The Member-Secretary,
Madras Metropolitan
Development Authority,
No.8, Gandhi Irwin Road,
Egmore, Madras-600 008.

A2/15985/90

Sub: MMDA - Planning Permission - Construction
of Residential

building in Plot No. ABCD
at S.No. 22, 25/1 of Seevaram village -
Approved - Regarding.

PLAN OF PROPOSED DWELLING HOUSE FOR SRI K. MUTHAMMAL
 IN PLOT ABED IN SYM. 22x25% OF N. 144 SEEVARAM
 VILLAGE PERUNGUDI PANCHAYAT, SETHIL NAGAR.

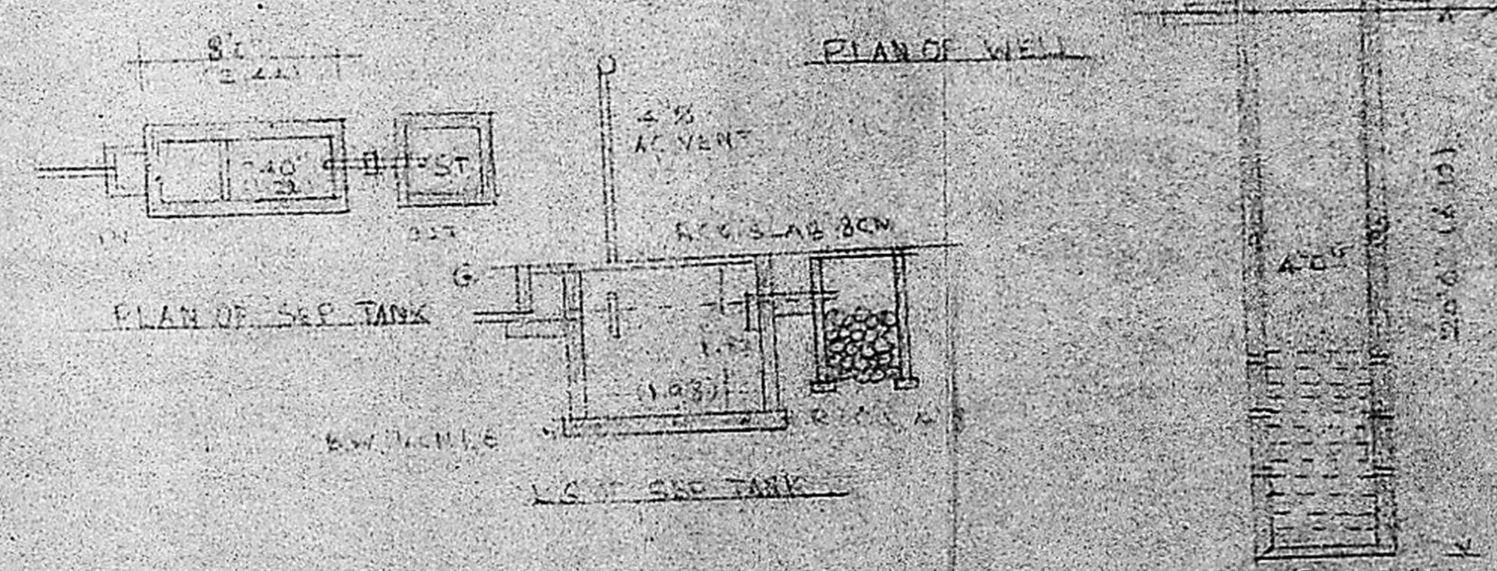
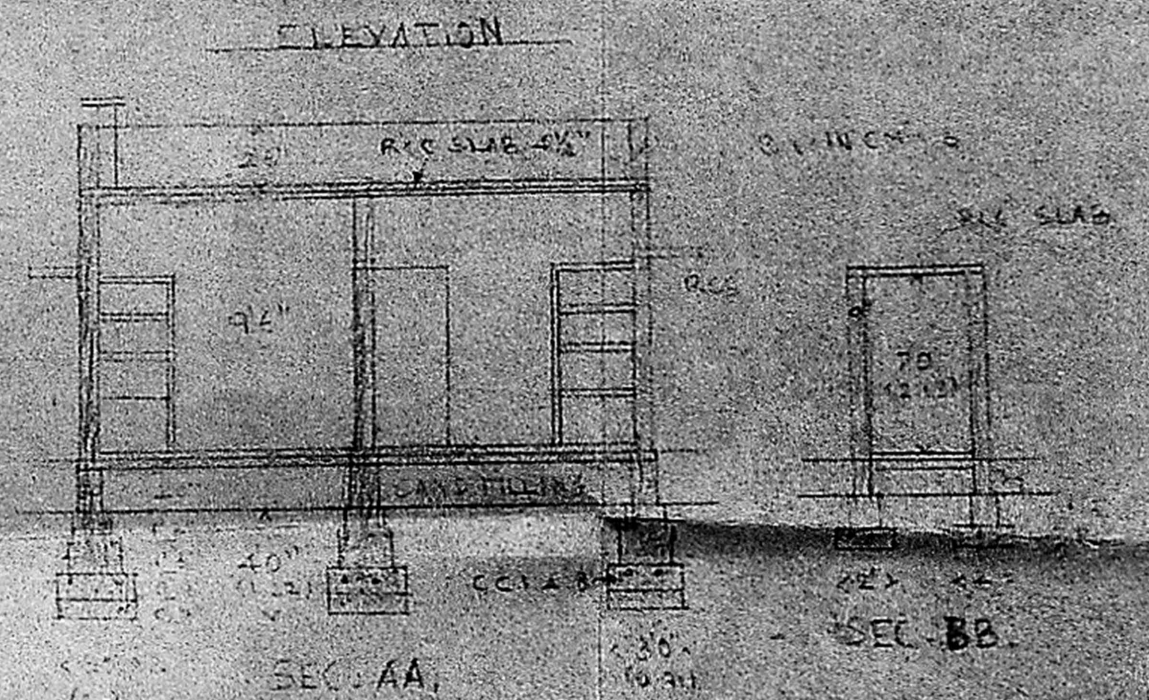
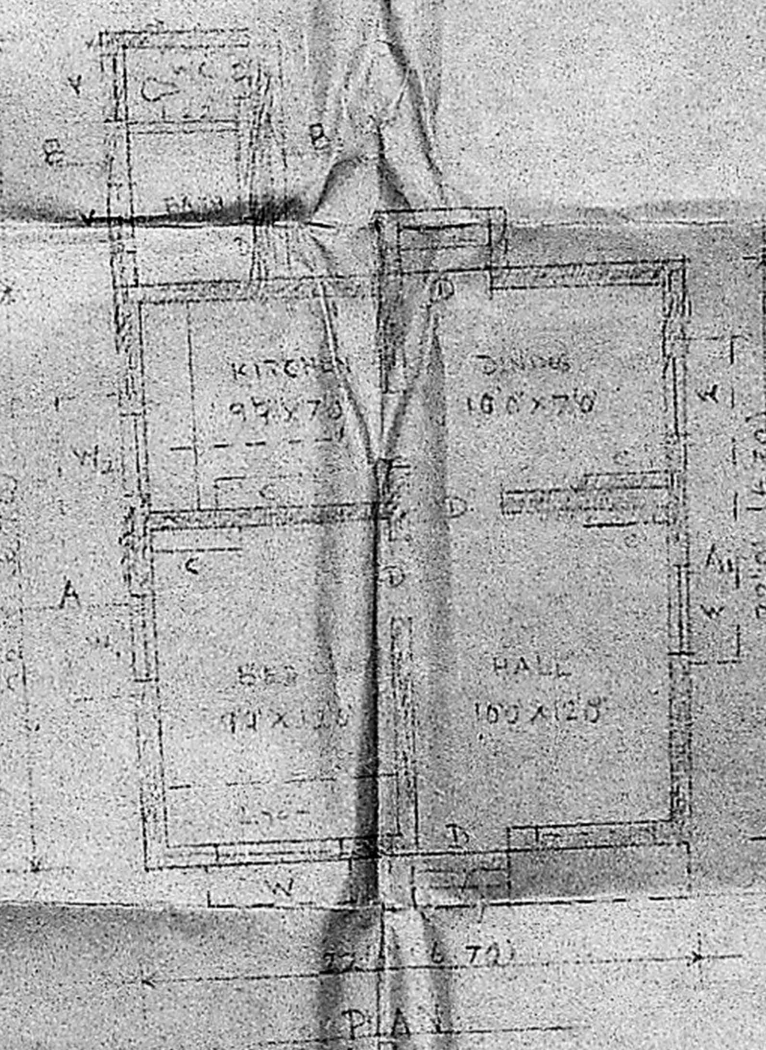
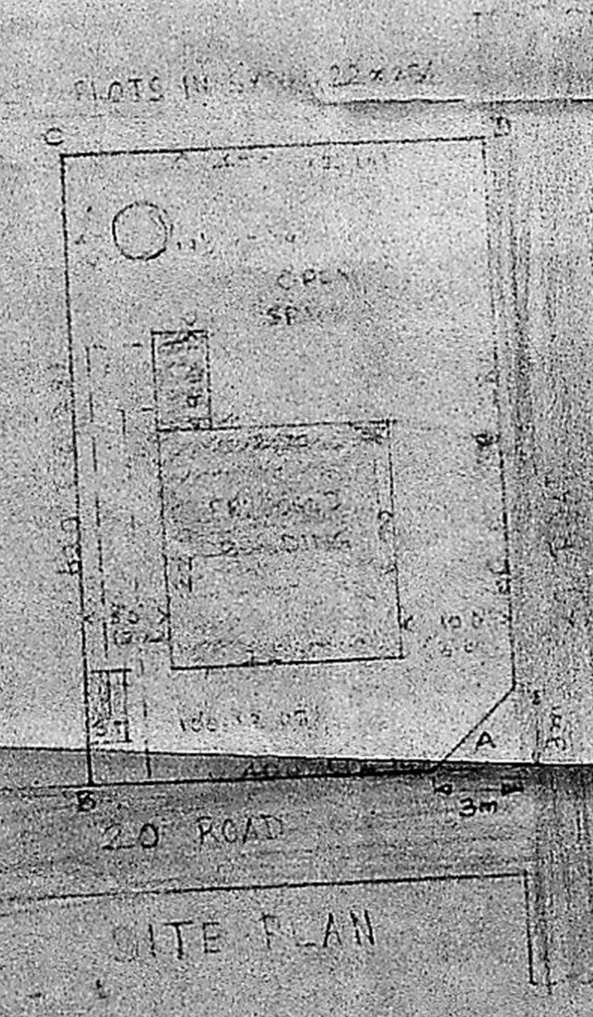
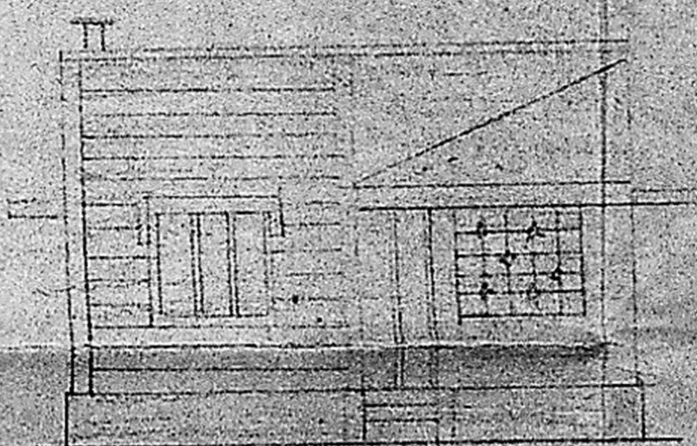
You are requested to furnish
revised plan showing the name of Nagar in which plot under refer-
ence lies on receipt of the amount, the approved plans will be
sent to the
